EIAR ADDENDUM APPENDIX 15-3A

**ADDENDUM STAGE 1 ROAD
SAFETY AUDIT**

Item 1.7 raised by the Commission states the following;

PROJECT TITLE:			
Laurclavagh Renewable Energy Development, Co. Galway			
DRAWING TITLE:			
Proposed access junction off the L-61461			
PROJECT No.:	DRAWING No.:	SCALE:	
210627	210626 - 39	1:1,000 @ A3	
DRAWN BY:	CHECKED BY:	DATE:	REVISION.:
JOB	TH	13.03.2024	P01

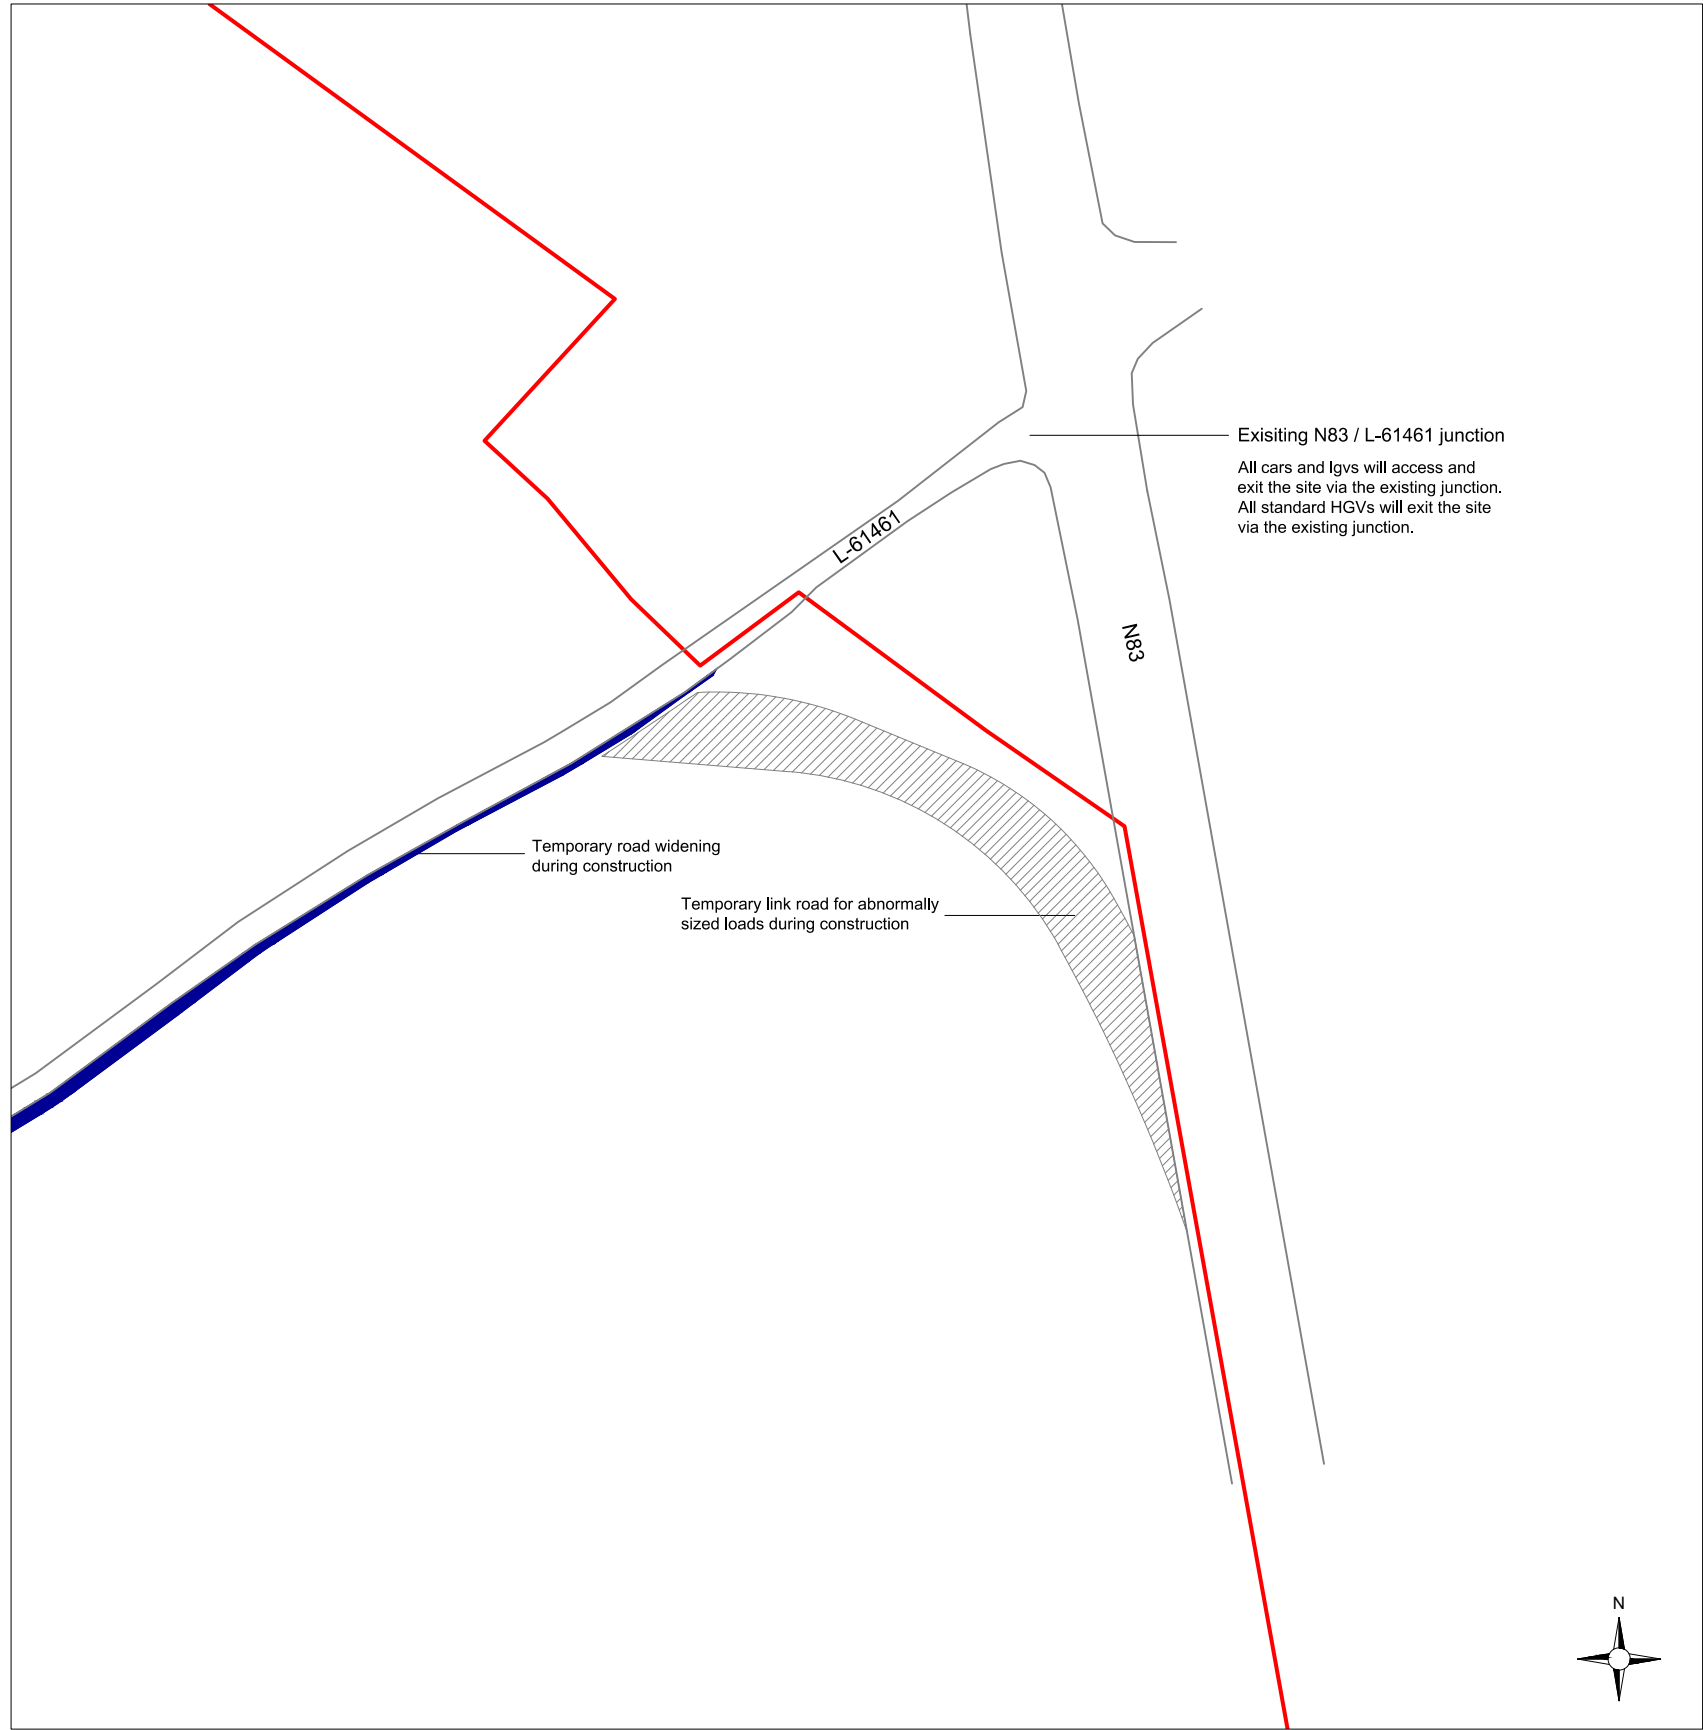
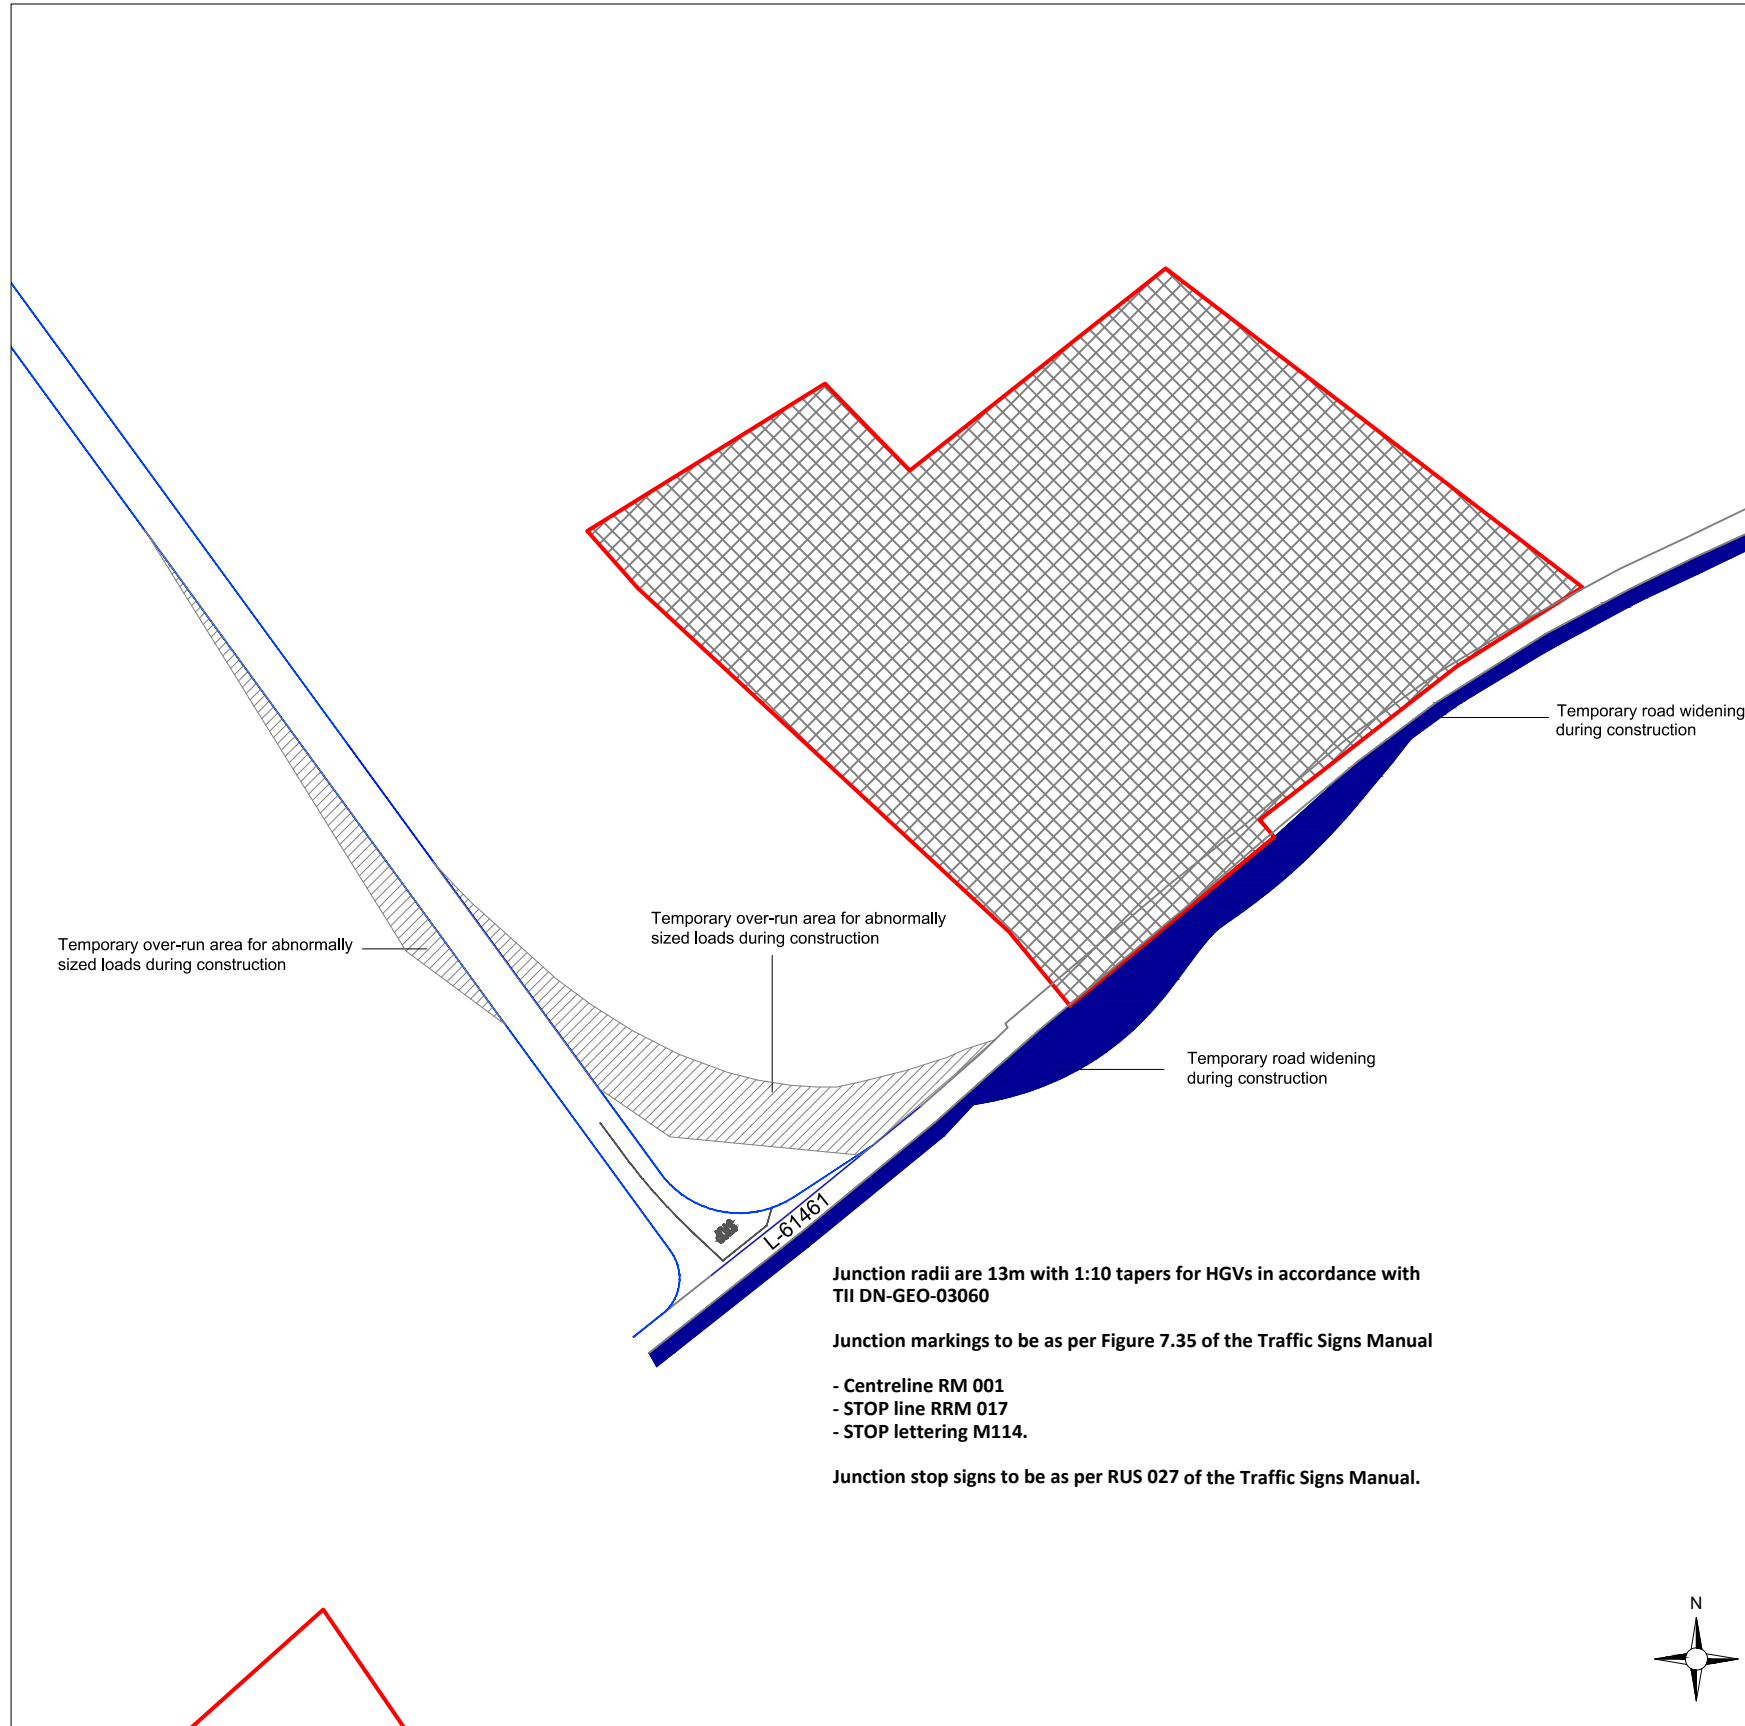
Issue 1 – Updated Audit to respond to Item 1.1 raised by the Commission - The N83 / L-61461 junction layout as outlined in submitted plans, the traffic management plan and in your response to submissions do not appear to be consistent with the existing onsite arrangement. The existing junction layout appears to display restricted sightlines in both northerly and southerly directions onto the N83. Given the application details submitted to date and the existing junction layout, consultation should take place with the planning authority in order to clarify the status of the existing junction layout.

Issue 2 – Updated Audit to respond to Item 1.2 raised by the Commission - You are requested to submit a revised site layout plan at an appropriate scale indicating clear sightline triangles at the required standard including at the N83 / L-61461 junction. This shall clearly dimension the extent of proposed boundary walls to be set back adjoining the L61461 and adjoining the N83. Sightlines at all entrances and junctions should meet required standards.

Issue 3 – Updated Audit to respond to Item 1.4 raised by the Commission - Site layout plans should be revised to clearly detail the width of L-61461 and its proposed widened areas, at an increased scale, taking into account the width of 2 number passing HGVs.

Issue 4 – Updated Audit to respond to Item 1.5 raised by the Commission - The site layout plans should be revised to detail existing junction layouts at the N83 – local roads.

Applicants Response – The 2 different junction layouts are discussed in detail in the **Responses to ABP Issues Report**, including Figures FI1 to FI4 in Appendix 15-5 of the Report. In summary the previous layout at the N83 / L-61461 junction included the STOP line of the minor arm of the junction being located adjacent to the carriageway edge, as opposed to the nearside edge of the hard shoulder, which permitted the full 3.0m x 215m visibility splays required for a 100 kph speed limit to be available. The junction layout has since been revised to include the relocation of the STOP line to be in line with the nearside of the hard shoulder. The recently implemented changes to the junction markings have been implemented without any alterations to the boundary walls running parallel to the N83, and as a result, there are significant restrictions to the visibility splays for drivers accessing the N83 from the L61461, as are shown in Figure FI4 of the in Appendix 15-5 of the Report. Measured from a minimum setback of 2.4m as permitted as a relaxation in TII Guidelines, as a result of the boundary walls now constraining visibility splays, a maximum of 35m is available to the north, and 20m to the south.

The recent design changes at the N83 / L61461 junction were designed and implemented by a Local Authority Roads Design Office on behalf of TII. The design of the changes including any implications relating to road safety are therefore the responsibility of these organisations. No design changes are proposed at this location as part of the Proposed Project. Temporary traffic management measures proposed during the various stages of the construction are discussed under Issue 1.2.2 of this report above.

Auditor Comment – I have reviewed ABP’s item 1.7, the Designer’s response and the road drawings which have been revised following the issue of our road safety audit.

All items raised in the road safety audit appear to have been suitably addressed within the revised site layout drawings.

In my opinion, the design changes fall under the heading of ‘design development’ and are unlikely to pose any further road safety risks (other than those raised within our audit).

On this basis, I do not see any need to revisit or update the road safety audit.
